**KIRKLEES METROPOLITAN COUNCIL  
INVESTMENT & REGENERATION SERVICE**

**DELEGATED DECISION TO DETERMINE PLANNING APPLICATIONS TO  
CARRY OUT DEVELOPMENT WITHOUT COMPLIANCE WITH PLANNING  
CONDITIONS PREVIOUSLY ATTACHED**

| Reference No:         | <b>2023/70/90747/W</b>                                                                                                                                                                                                                                                           |
| Site Address:         | 5, Southway, Lindley, Huddersfield, HD3 3LN                                                                                                                                                                                                                                      |

7. Proposed Roof Layout
Scale 1:100

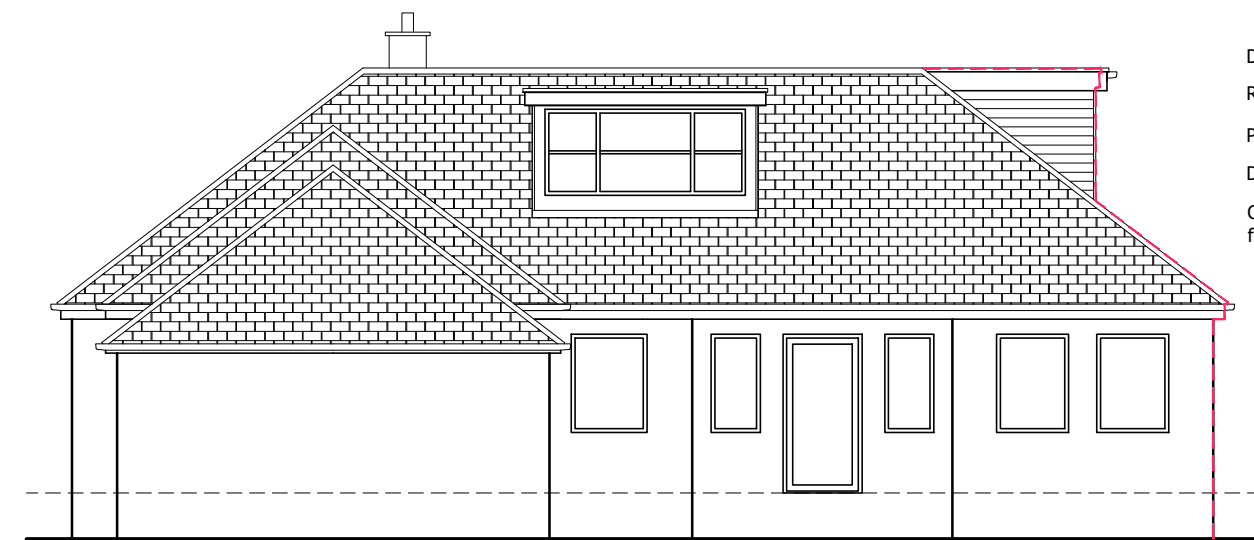
- Small front dormer approved to be enlarged has been constructed with a flat roof but with white fascias

The plans for this application appear to be similar to that approved via the 2021 application. As the finishing colour of the window frames were not conditioned and were not annotated plan to change the colour of the frames would not be breach of any planning condition. Therefore, this element of the proposal is acceptable.

8. Proposed East Elevation (Front)
Scale 1:100

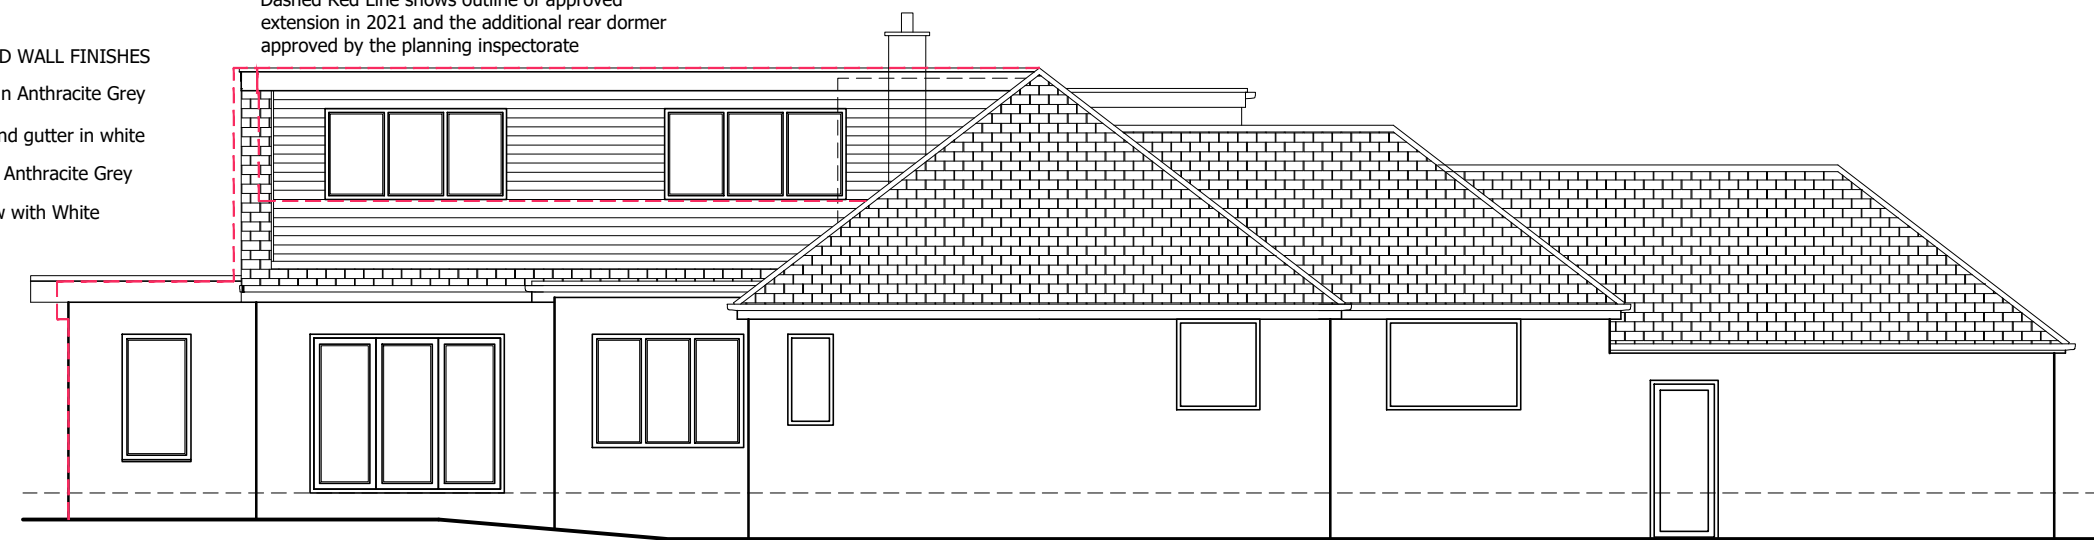
- Large south facing box dormer has been built with a flat roof with a larger overhang to the eaves and white fascia windows rather than grey

The south facing dormer has been constructed which has a lower eaves height to that approved in the 2021 application. The dormer faces into the garden area of the property and whilst deeper than that approved, it is considered to be visually acceptable. The Supporting Statement justifies the use of white for the soffits and window openings by stating that the materials were annotated on the 2021 application approved plans were in terms of render and roof tiles however it states that the previous plans.....*'does not specify the materials for the other elevations or roof plans of the development. In light of the above, there is doubt about the other materials not annotated, on the different elevations and as mentioned, even when annotated, colour, texture and quality and not mentioned..... the drawing seeks to avoid any doubt as to the proposed finishes to the building'*. The Statement is correct in that the previous plans 'indicated' the colour on plans however the materials for details not annotated on plan were not conditioned. This in itself is not unusual on a household development application. As such, given the siting of this dormer, facing into the garden with a fall-back position in terms of the previously approved plans with limited harm in terms of residential and visual amenity, this variation to this element of the proposal is acceptable.

10. Proposed West Elevation (Rear)
Scale 1:100

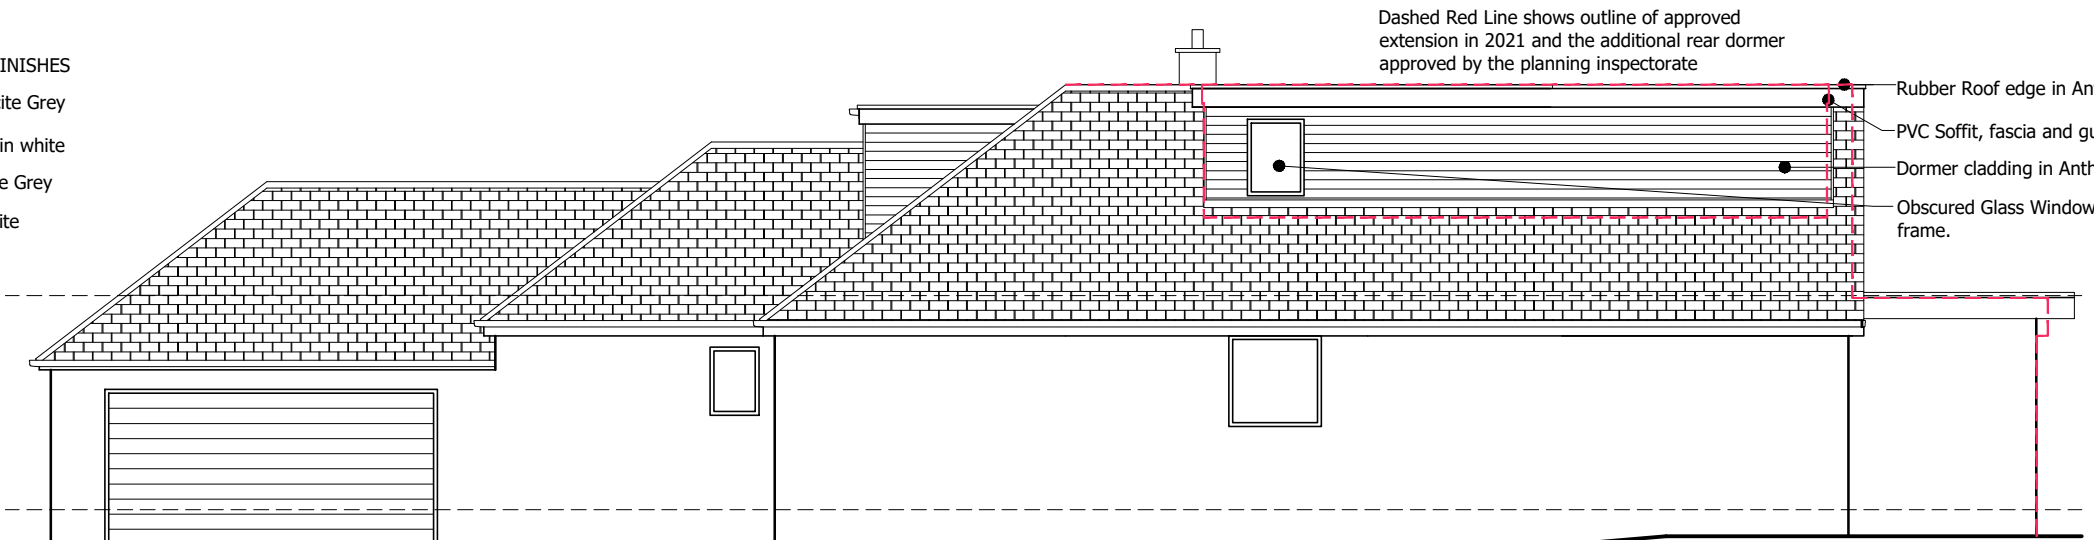
- Privacy compromised by a window on west facing gable which looks directly onto gardens and habitable rooms

Response: The window in the west facing gable was included as part of the 2021 approved scheme. As such, given the extant permissions which can be implemented in any case it is considered it would be unreasonable of the LPA to refuse permission on the basis of the impact of this opening in this case.

11. Proposed North Elevation (Side)
Scale 1:100

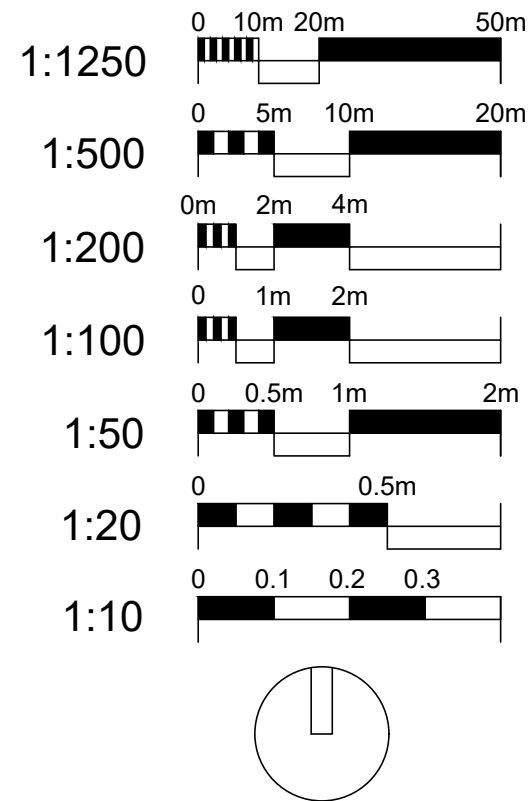
In terms of the works 'as built' the plans demonstrate the differences between the approved plans. It is not considered that there would be a significant impact resulting from the scheme submitted as part of this application from the extant permissions which can be implemented in any event. There would be no increase in overlooking and the concerns regarding the window within the north elevation dormer can be addressed by inclusion of a condition requiring this window to be obscure glazed.

2. Within 3 months of the date of this permission the window shown within the north elevation dormer extension shall be fitted with an obscure glazed top opening window with the lower part of the opening section no lower than 1.7 metres above the finished floor level. Notwithstanding the provisions of the Town and Country Planning (General Permitted Development) Order 2015 as amended (or any
